21 August 2019

MPE Stage 2 MOD 2 (SSD-7628-Mod-2) and MPE Concept MOD 3 (MP 10_0193 MOD 3)

Response to Submissions

| Title   | STORMWATER DRAINAGE<br>OSD OUTLET 09                          |  |

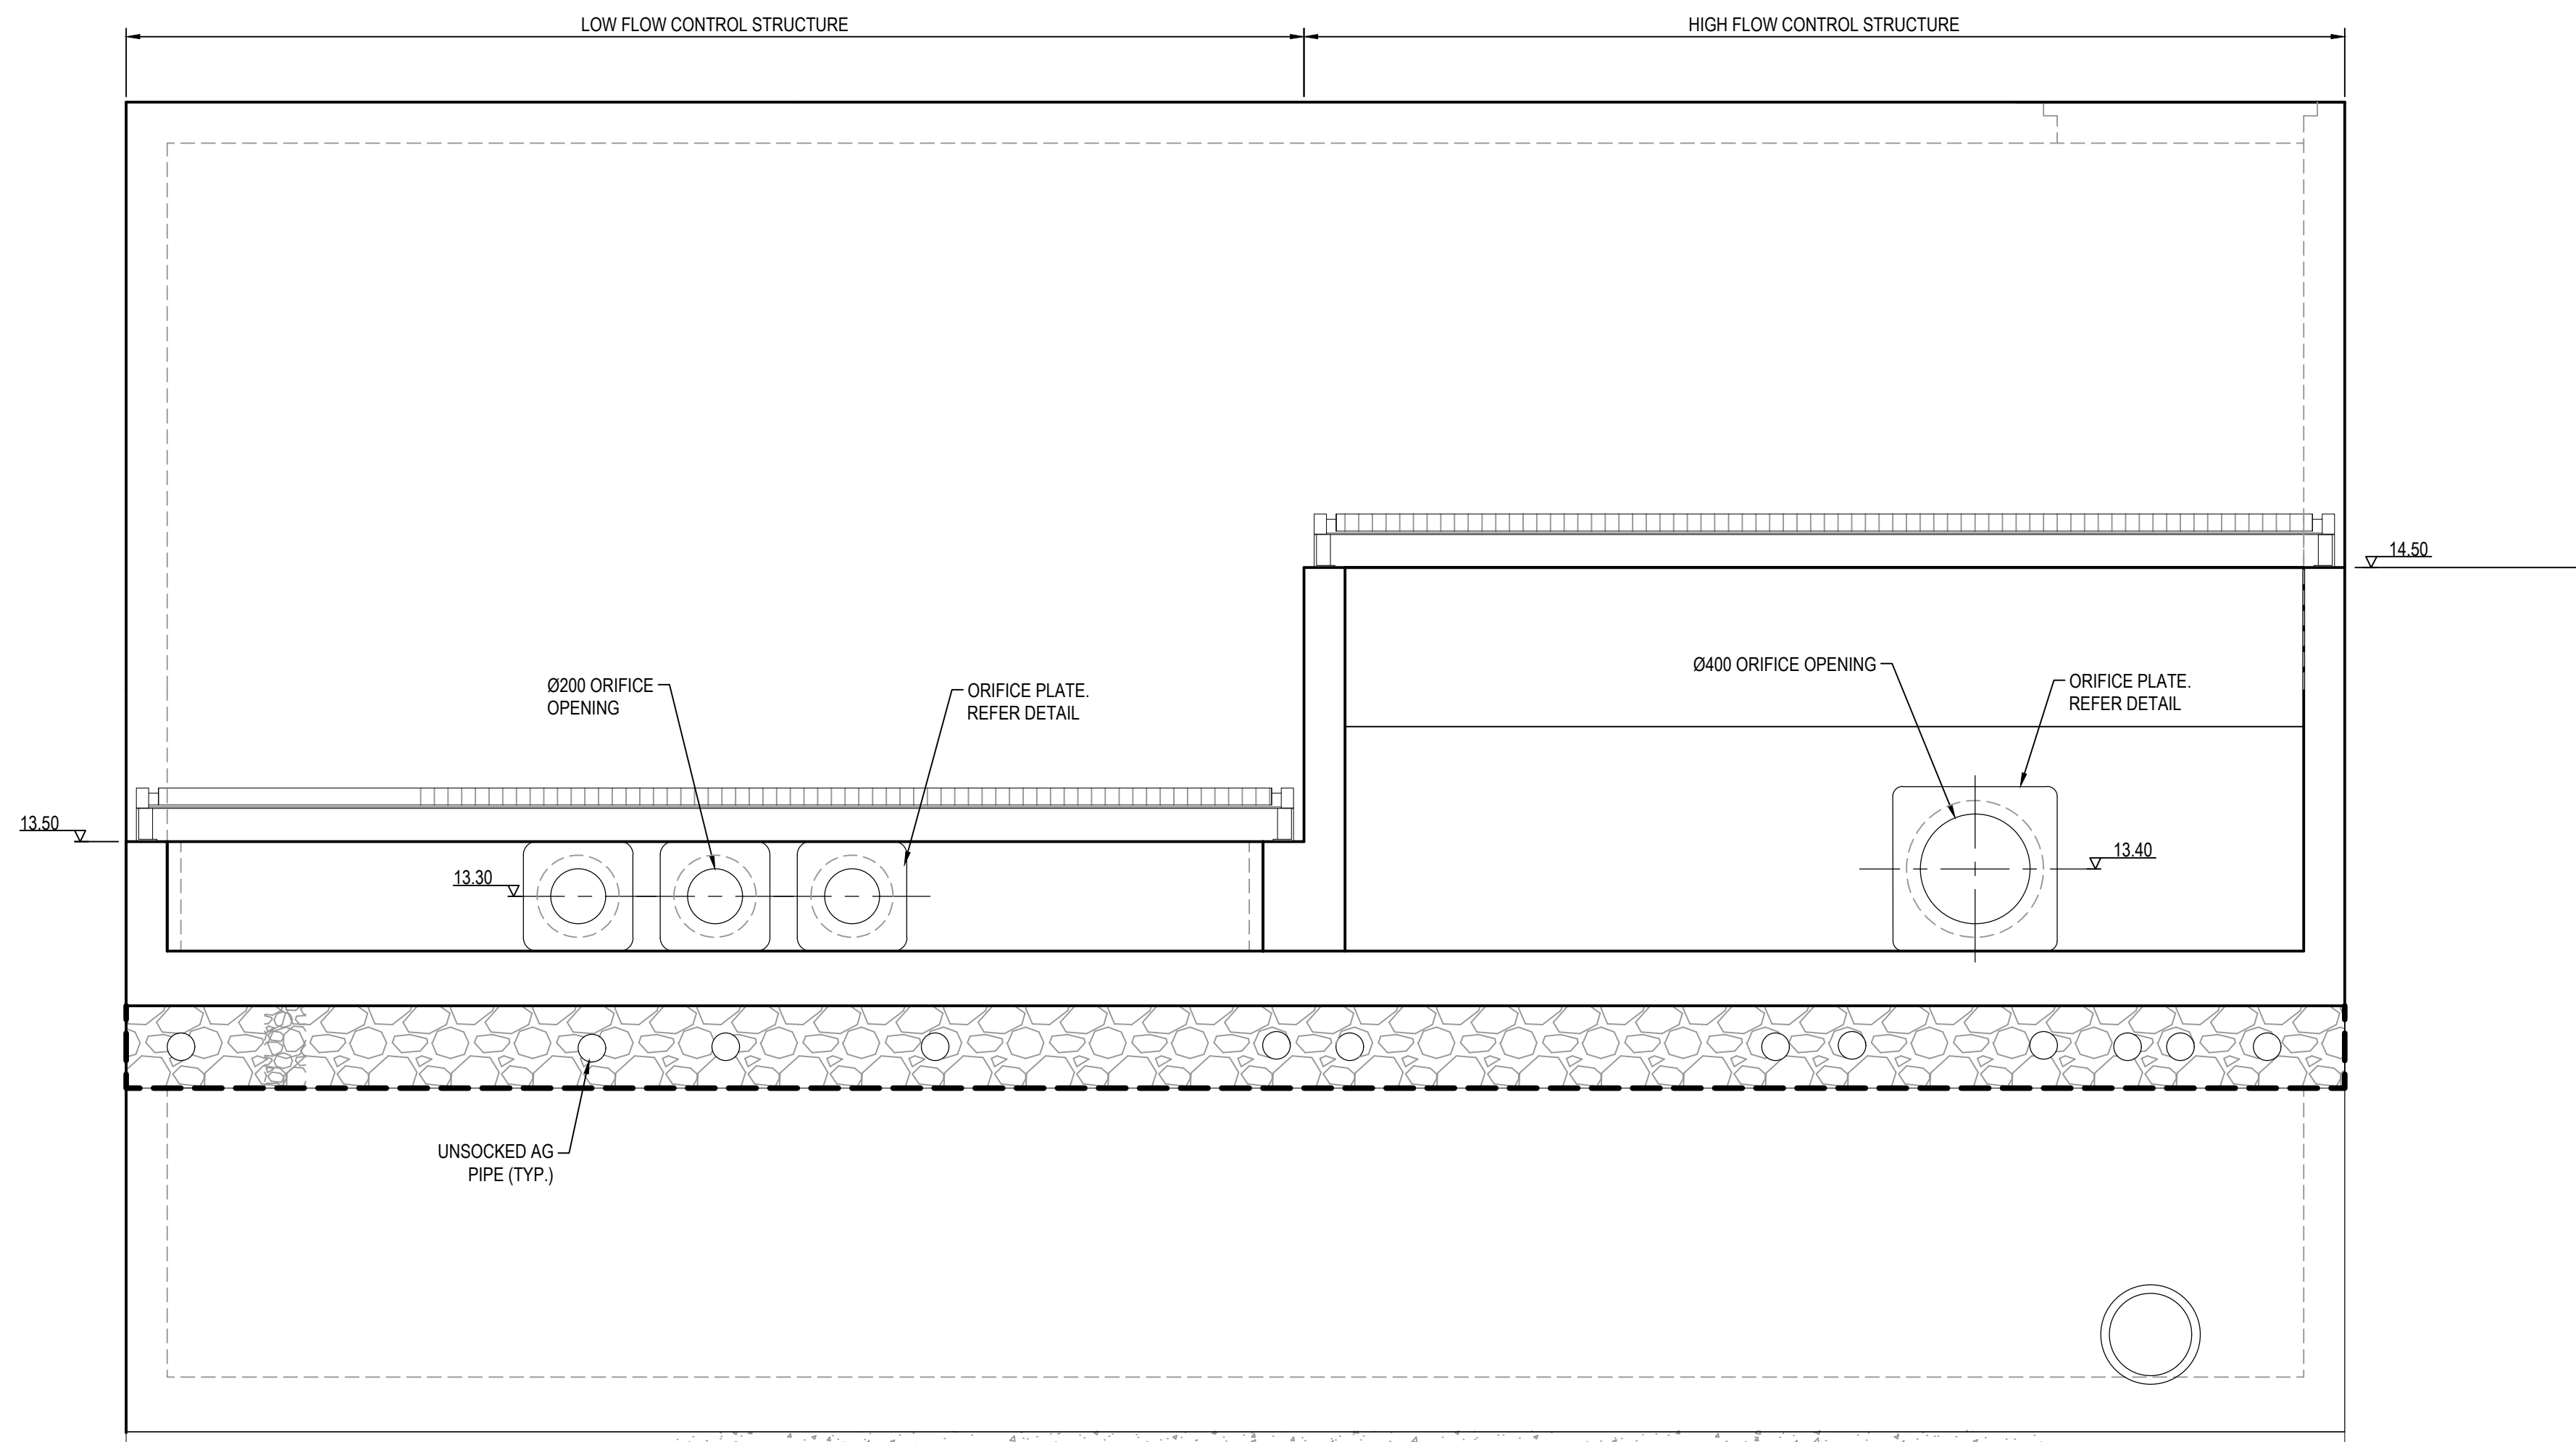
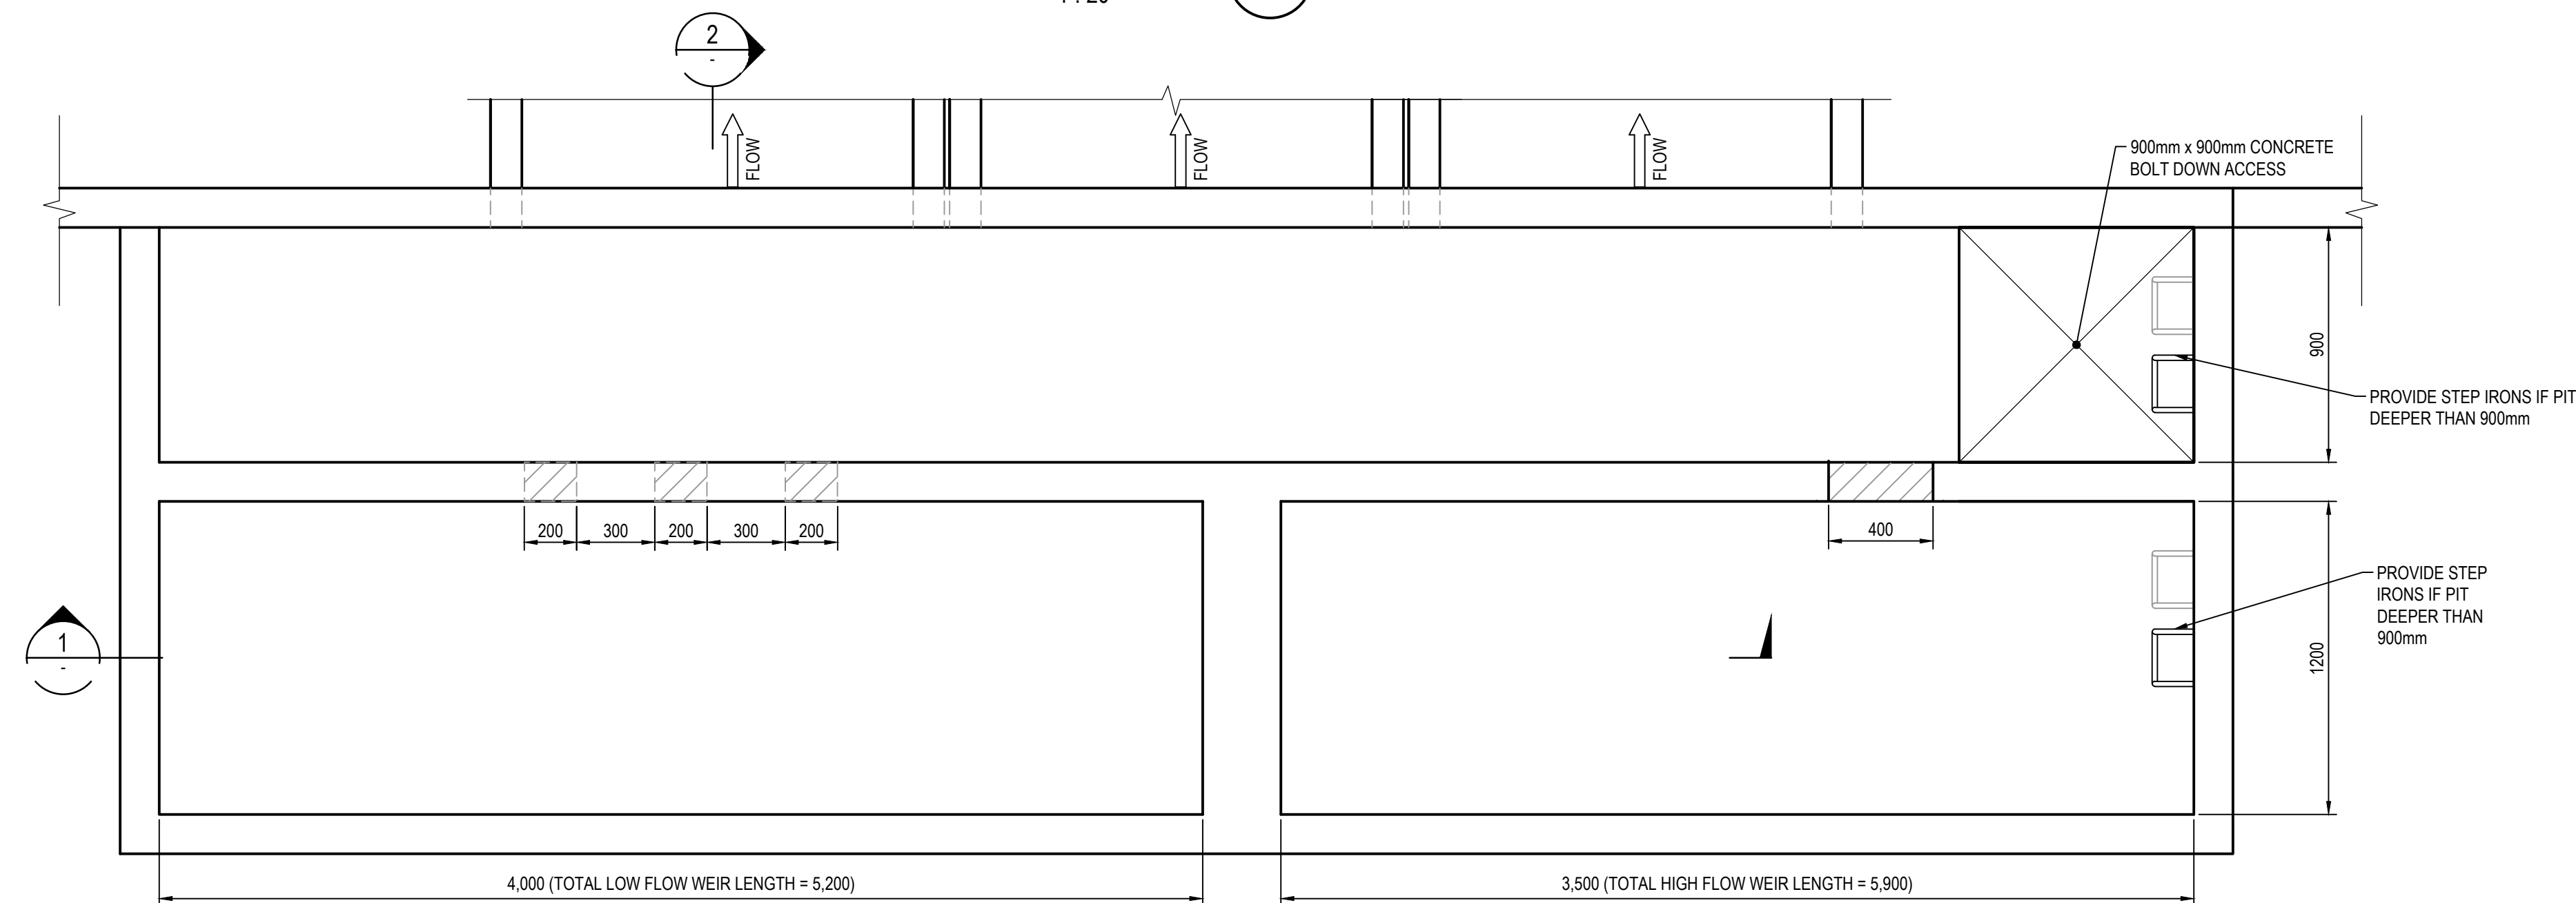
OSD basin 9 design changes

Insufficient detail has been provided in the modification application to enable the Department to complete its assessment in relation to:

- how the drainage design has been modified
- how the modified drainage design will function, particularly in relation to stormwater treatment.

- consolidated drawings showing OSD basin 9 (plan views and cross sections), including existing and finished surface levels, and the downstream bioretention area/ raingarden in the MPW site. It is recommended that you provide your most detailed drawings, such as work-as-executed drawings, in order for the Department to verify that the design can comply with relevant consent requirements
- construction schedule for installation and commissioning of the raingarden and repair of the existing open concrete channel (aka the 'east-west channel') on the MPW site
- details for treatment of stormwater from OSD basin 9 (plan views and sections), prepared by a suitably qualified professional, post-development of MPW Stage 2 (if approved).
